RE: Bubba's 33
10000 Coors Bypass NW
Grading and Drainage Plan
Engineer's Stamp Date: 04/14/21
Hydrology File: B14D004H

Based upon the information provided in your resubmittal received 04/19/2021, the Grading & Drainage Plan is approved for Building Permit.

To City of Albuquerque	Project: Bubba's 33 – Albuquerque, NM
Attn: Renée C. Brissette	
Senior Hydrology Engineer	Re: Grading and Drainage Plan Review Comments
505-924-3995	
rbrissette@cabq.gov	Hydrology File: B14D004H

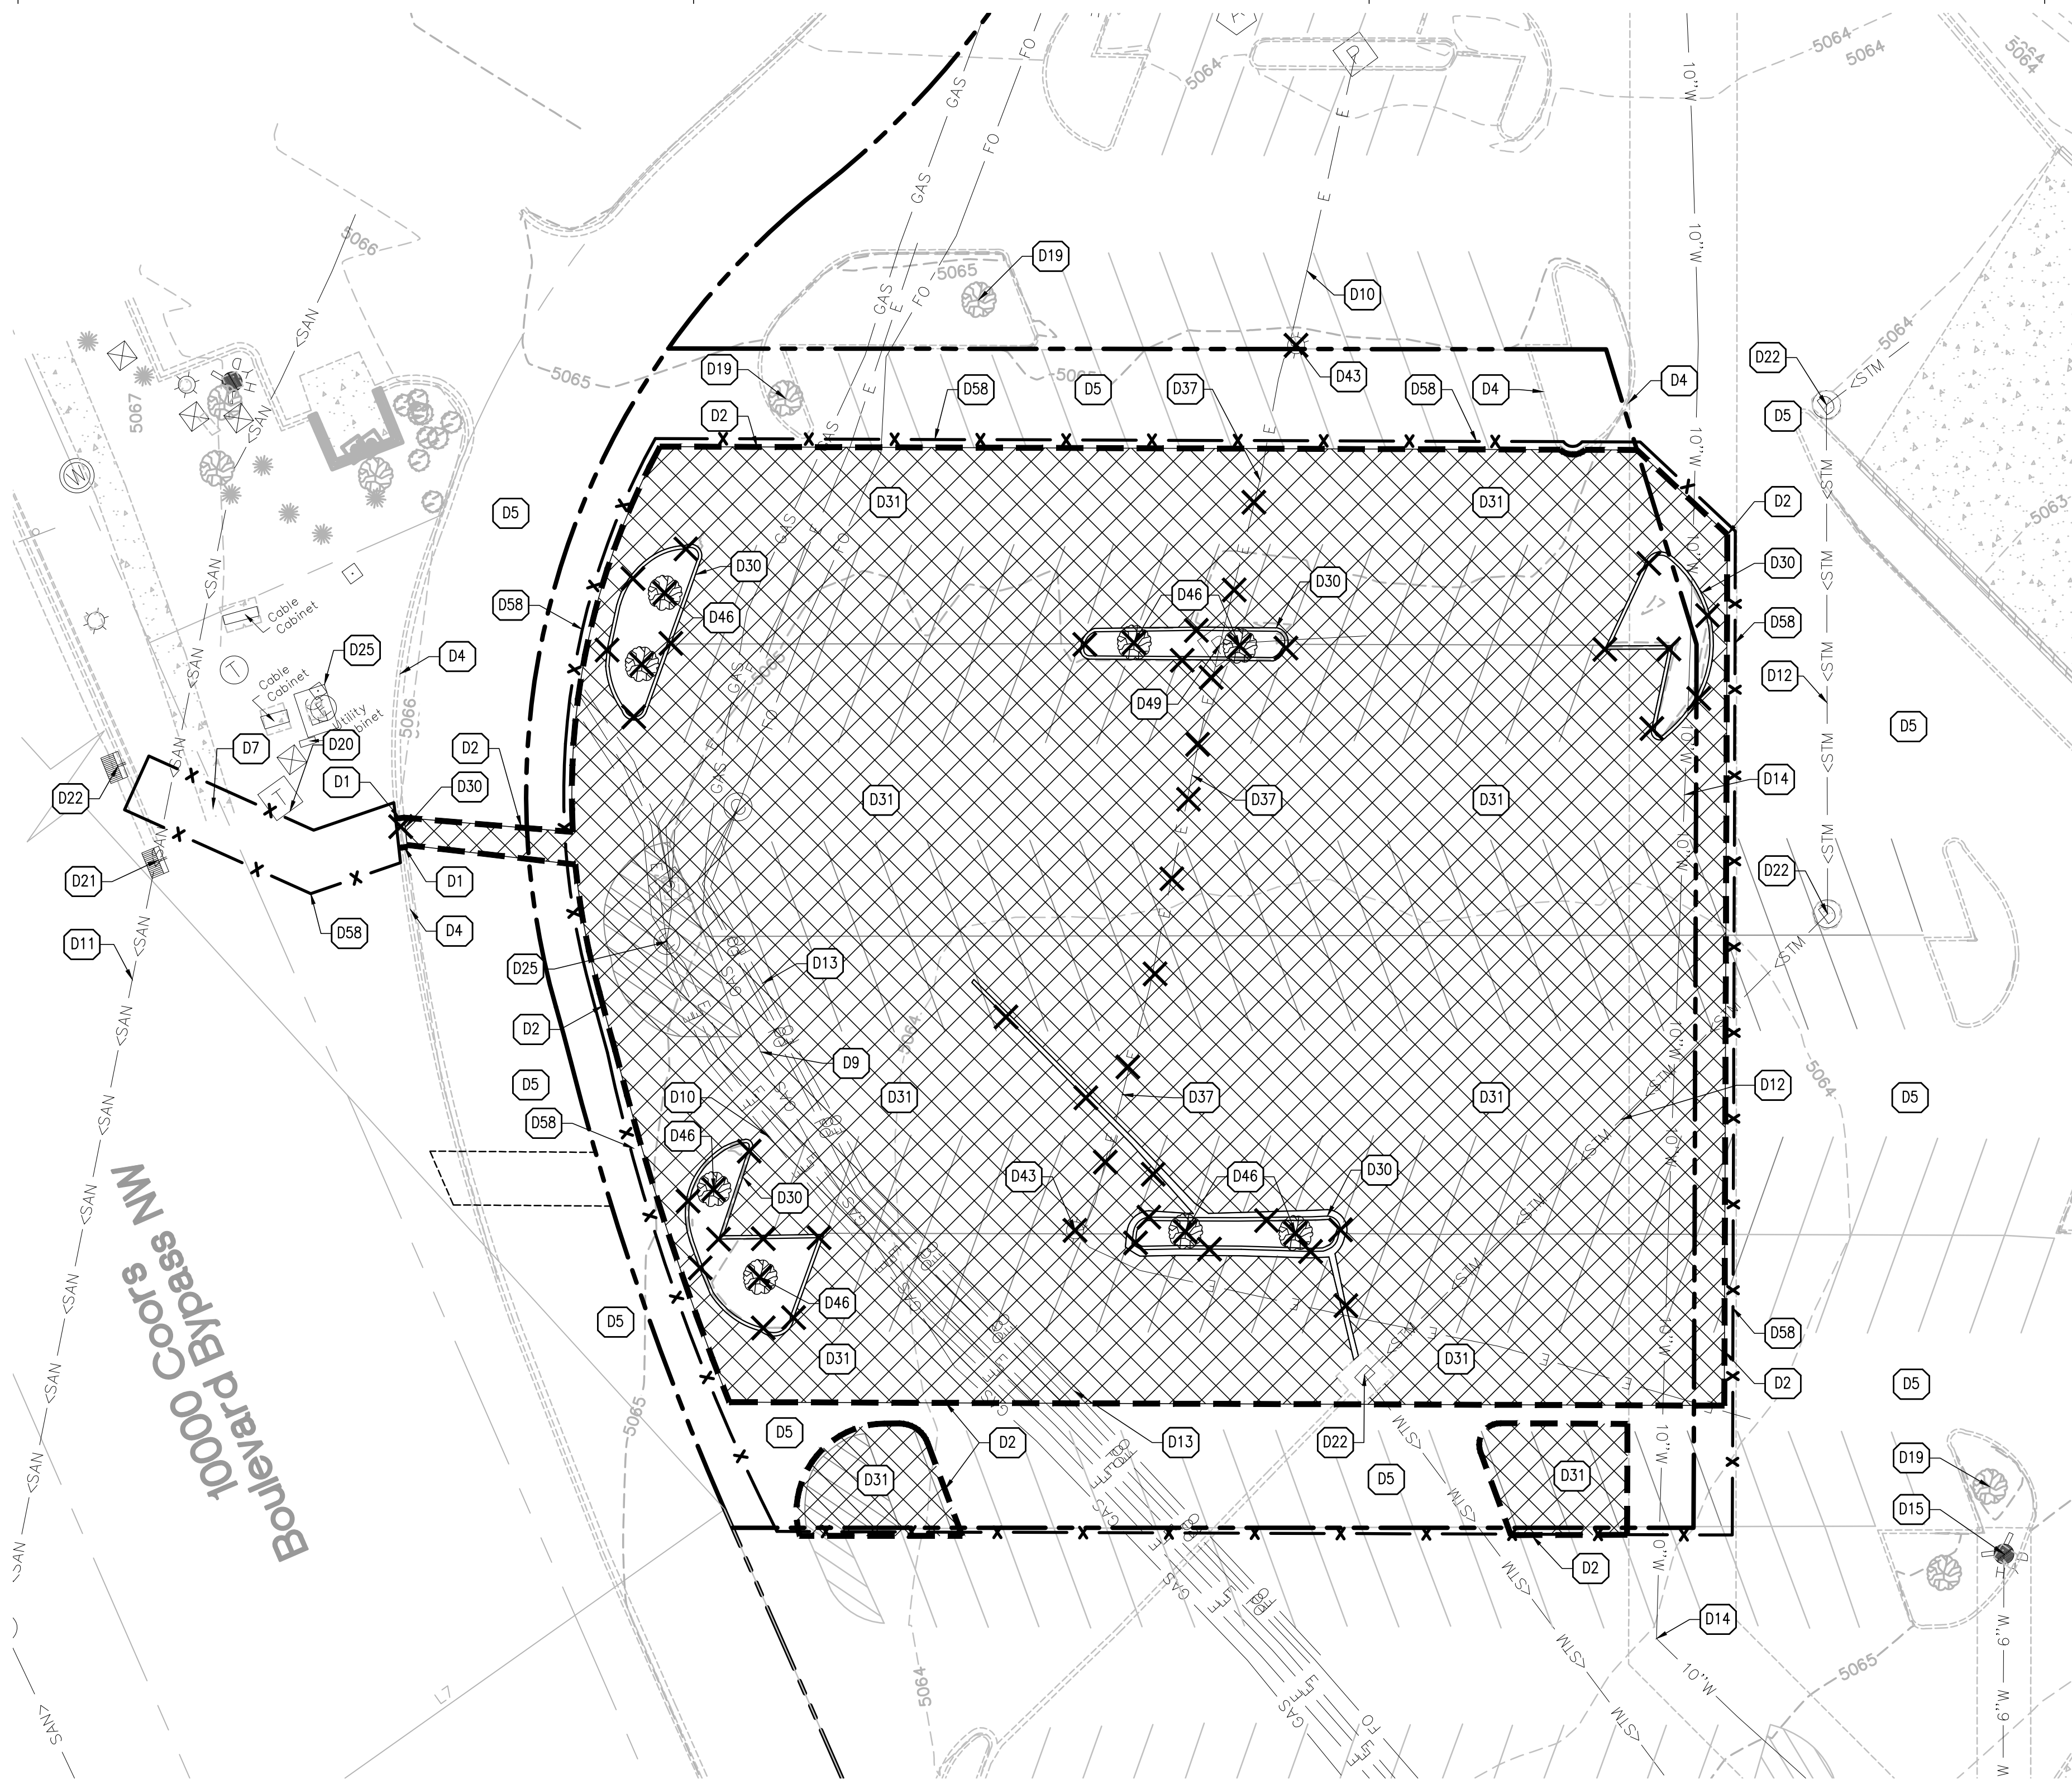
3. Please show the edge of saw cut of the existing pavement and label along this, "Match existing grades". I can see this on the Site Plan but I need the saw cut line here as well.

Response: The edge of proposed pavement lines are being shown and the "match existing grades" labels have been added to the C4.0 Grading and Drainage Plan.

**PRE/POST  
LAND USE  
COMPARISON**

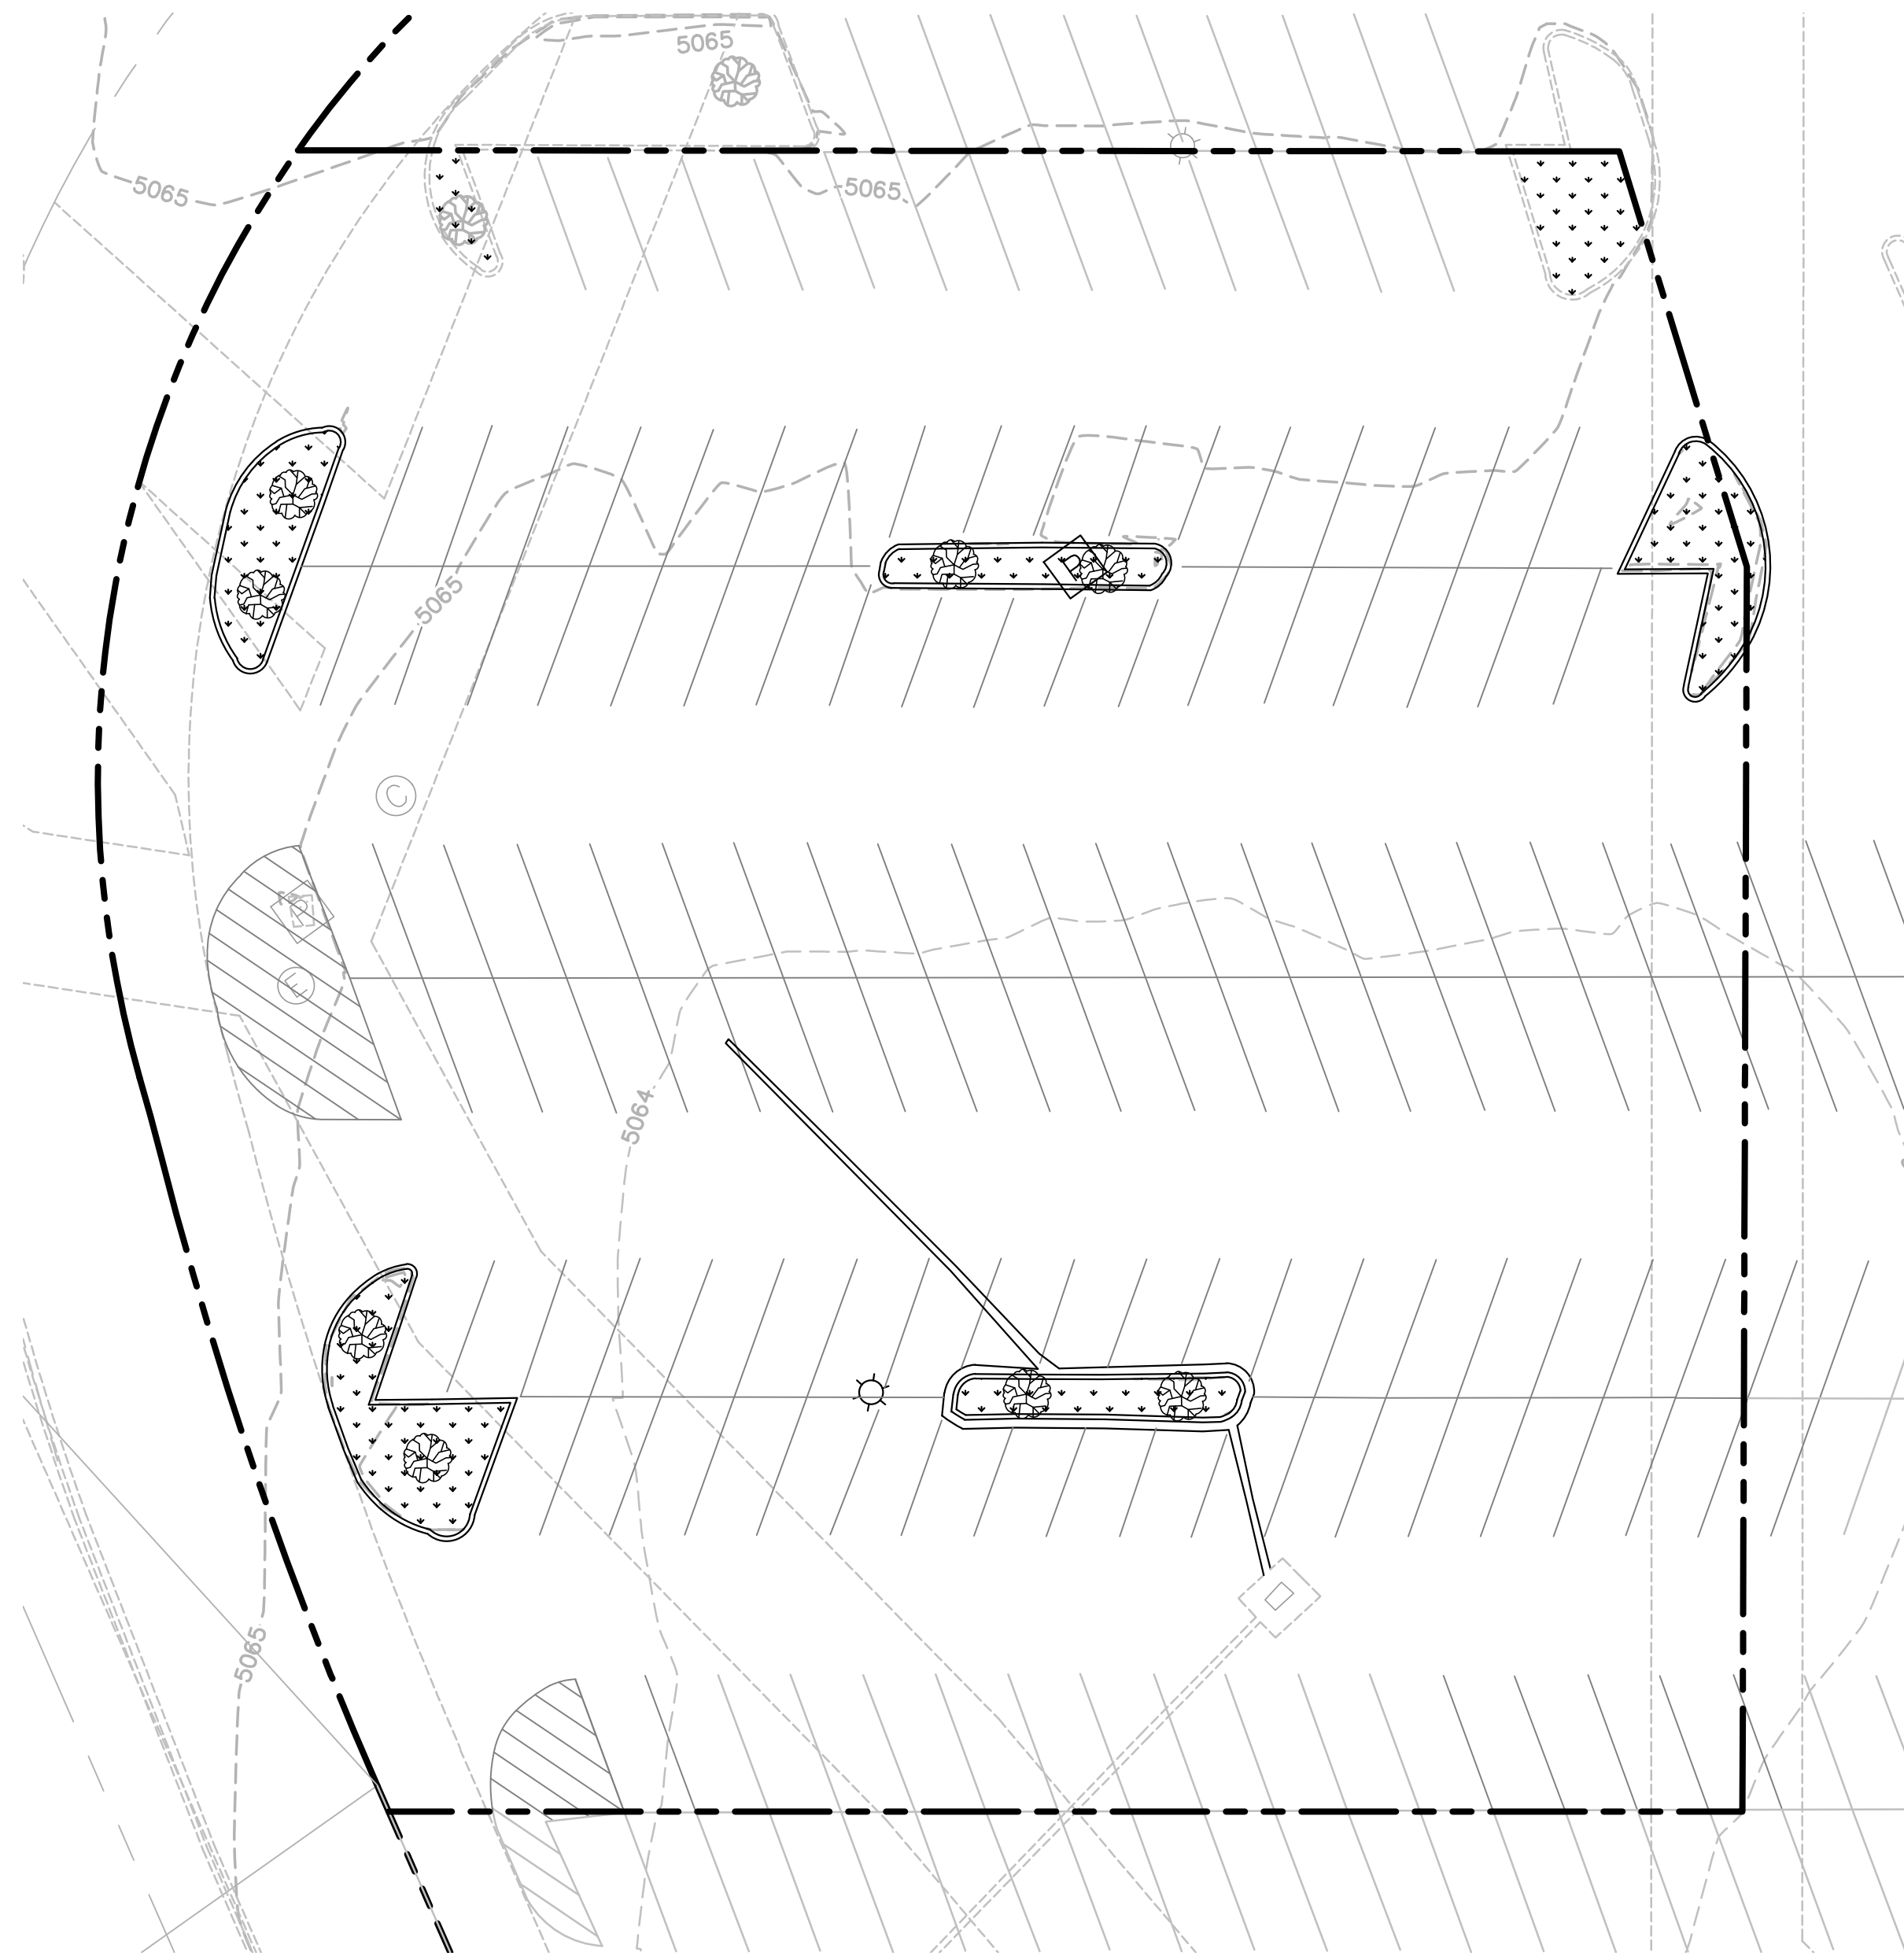
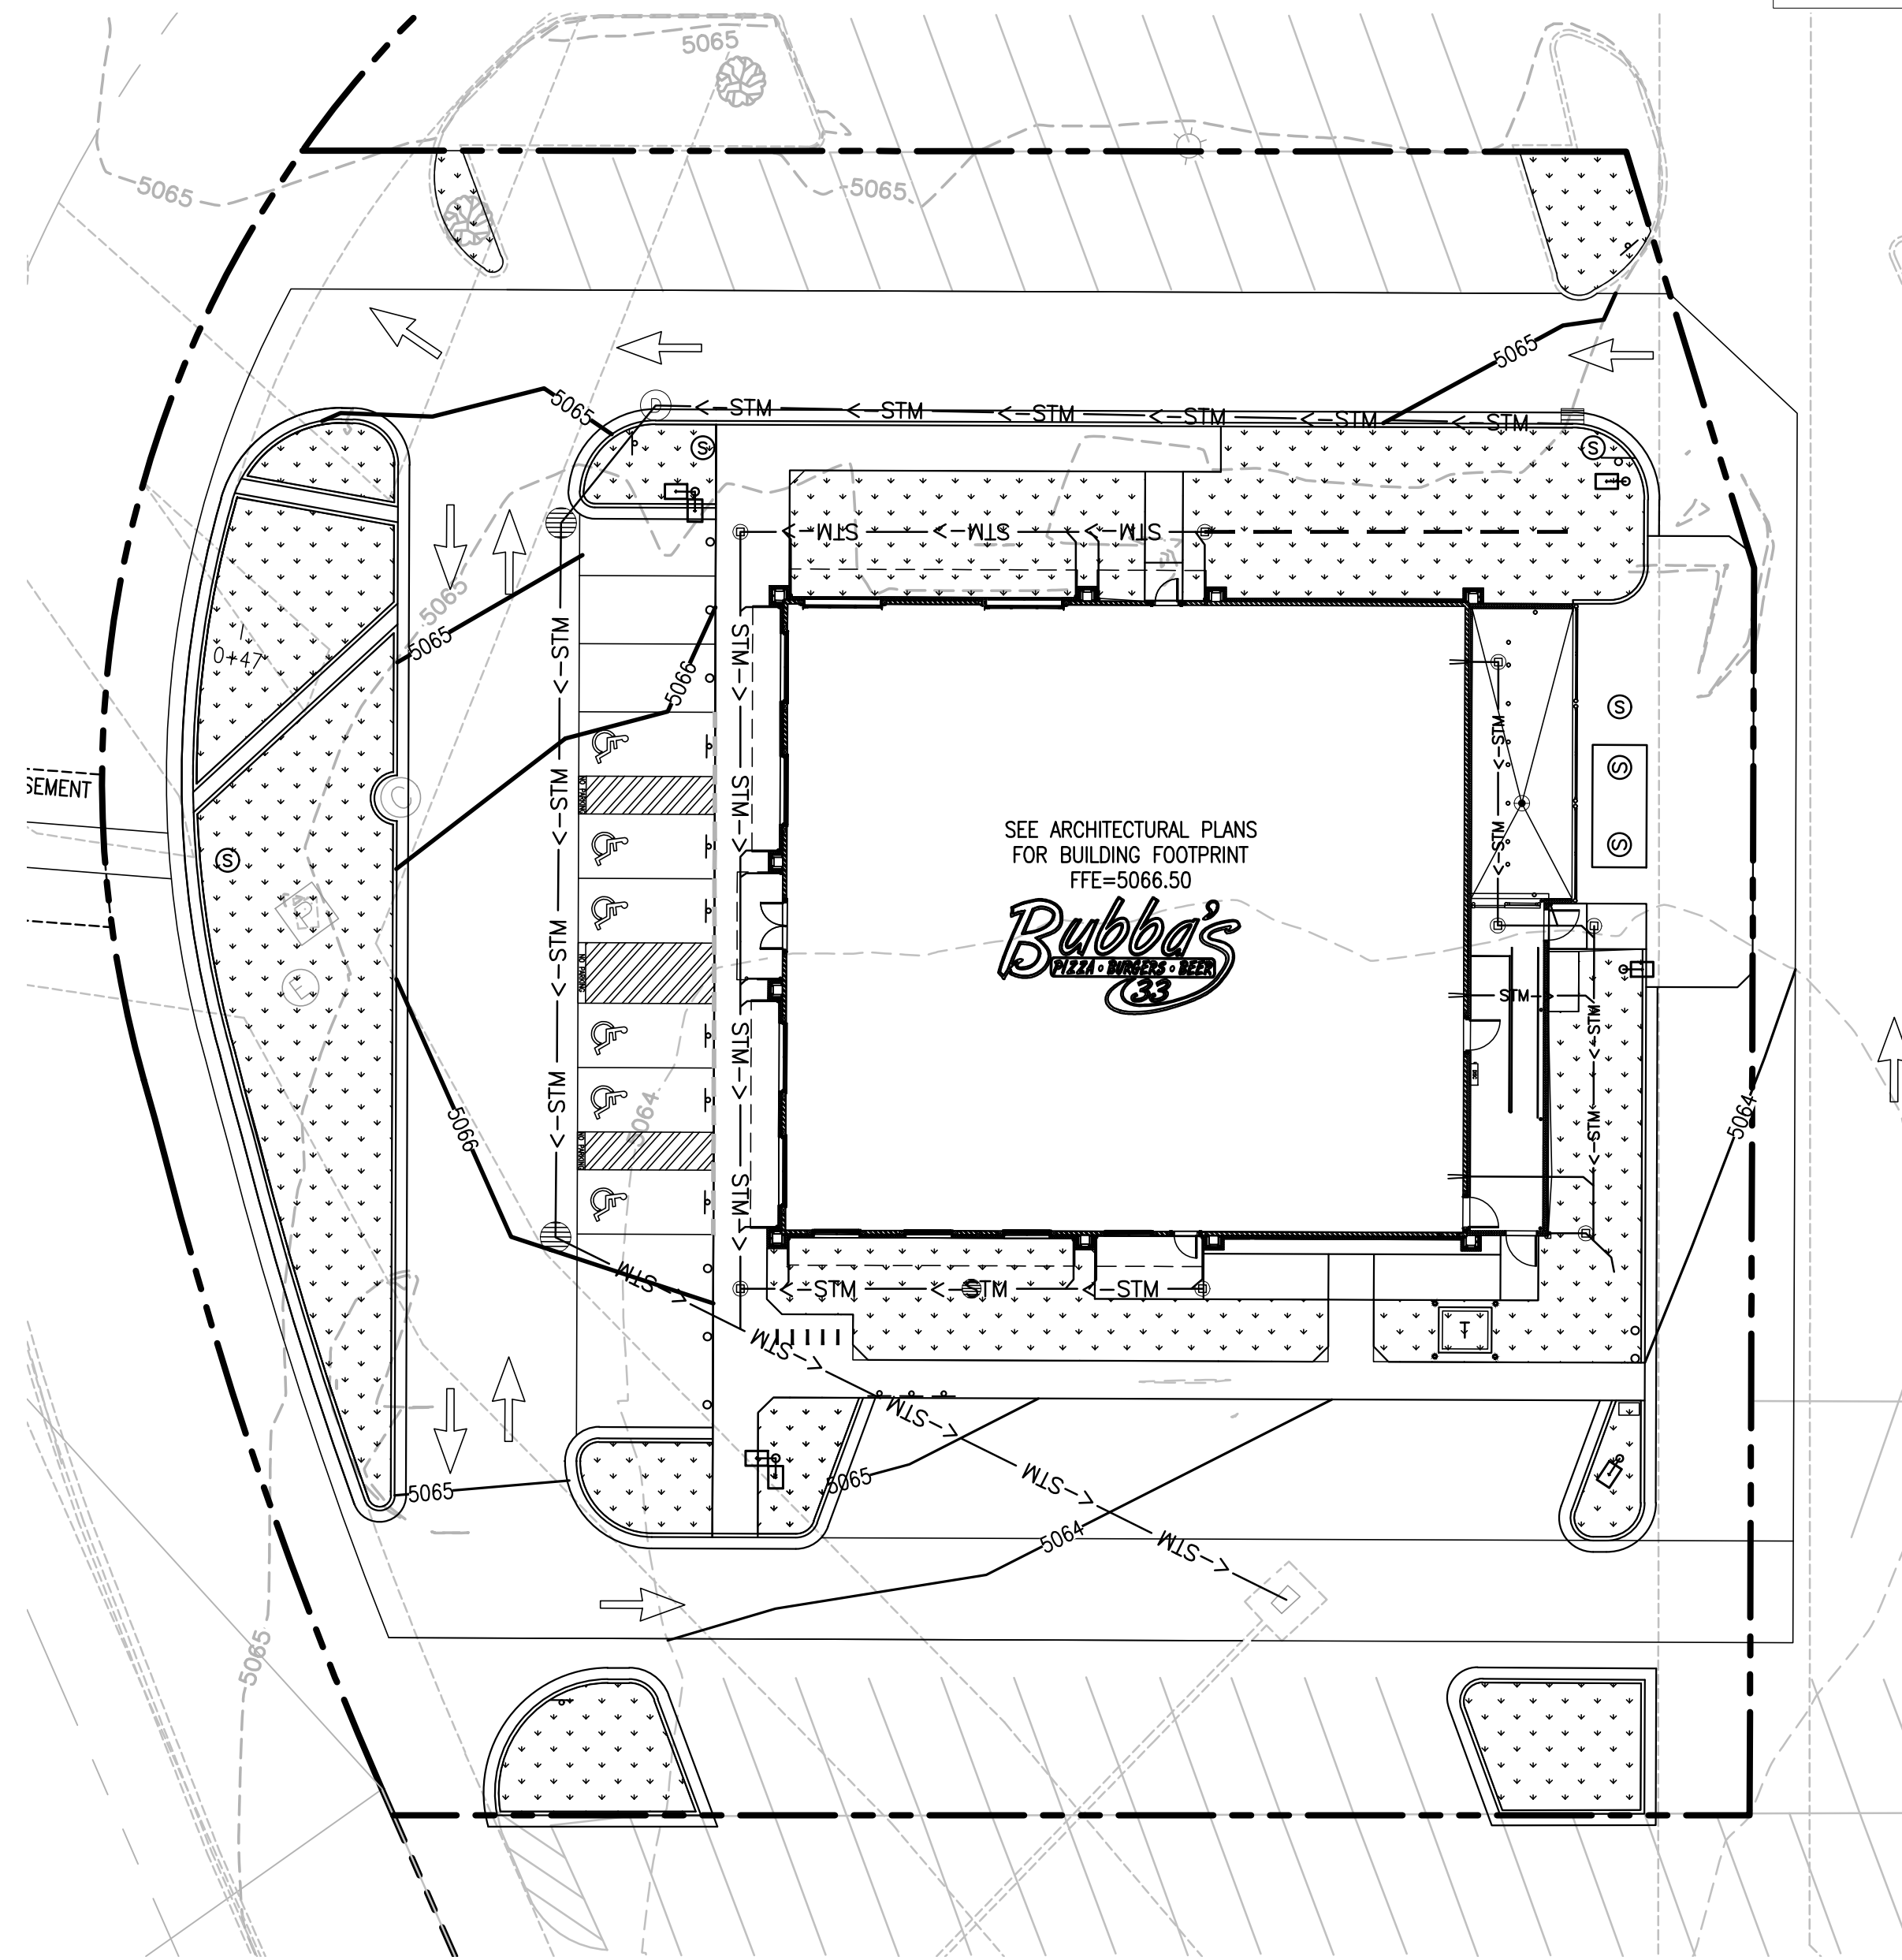
1. Please use the procedure for 40 acre and smaller basins as outlined in Development Process Manual (DPM) (signed 06/08/20) Article 6-2(a). Please provide both the existing conditions and proposed conditions for the 100-year 6-hour storm event.

Response: The existing/proposed storm event calculations have been added to the new C4.1 Pre/Post Land Use Comparison sheet.
